M5 Junction 10 Improvements Scheme

Change Application 2

**Schedule of Changes to draft Development Consent
Order**

TR010063 – APP 10.14

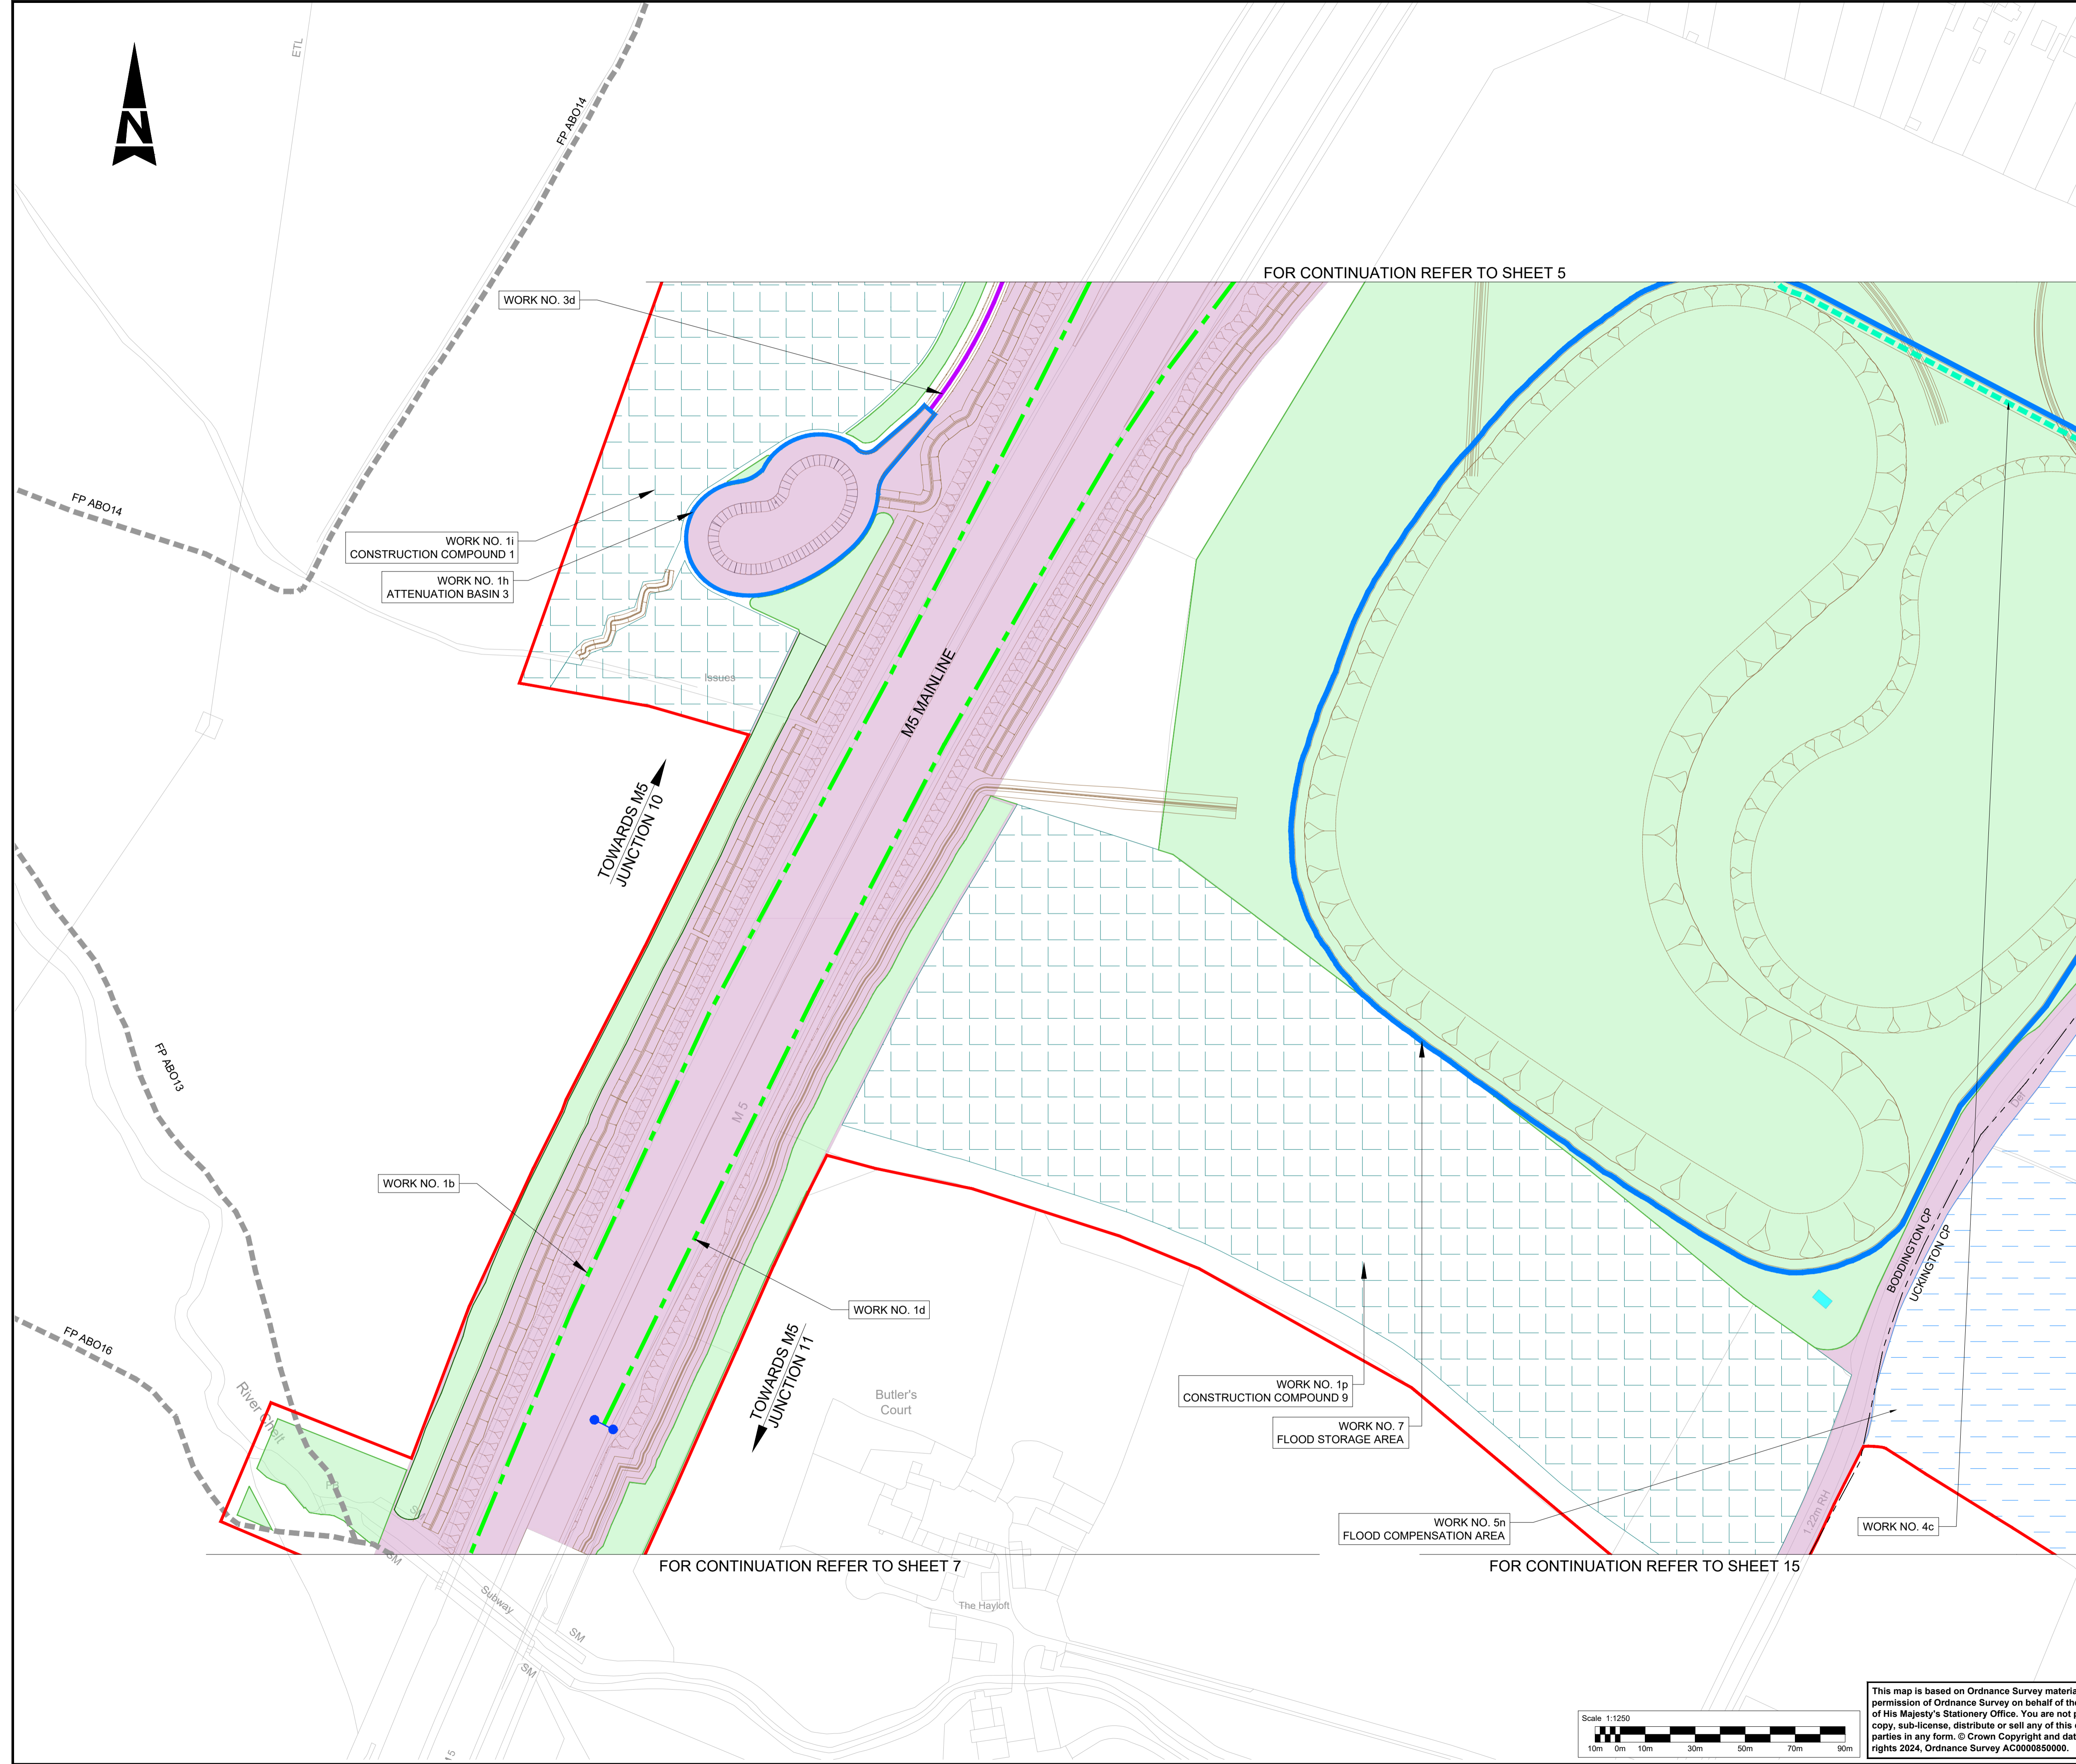
| Table of Amendments to the DCO | | |
|---|--|--|
| Schedule 1, Work No. 4 | Insertion of sheet 6 | This change is required to reflect that the BR AUC1 diversion is shown on sheet 6 of the work plans, which is part of Change 6 of this Change Application submission. |
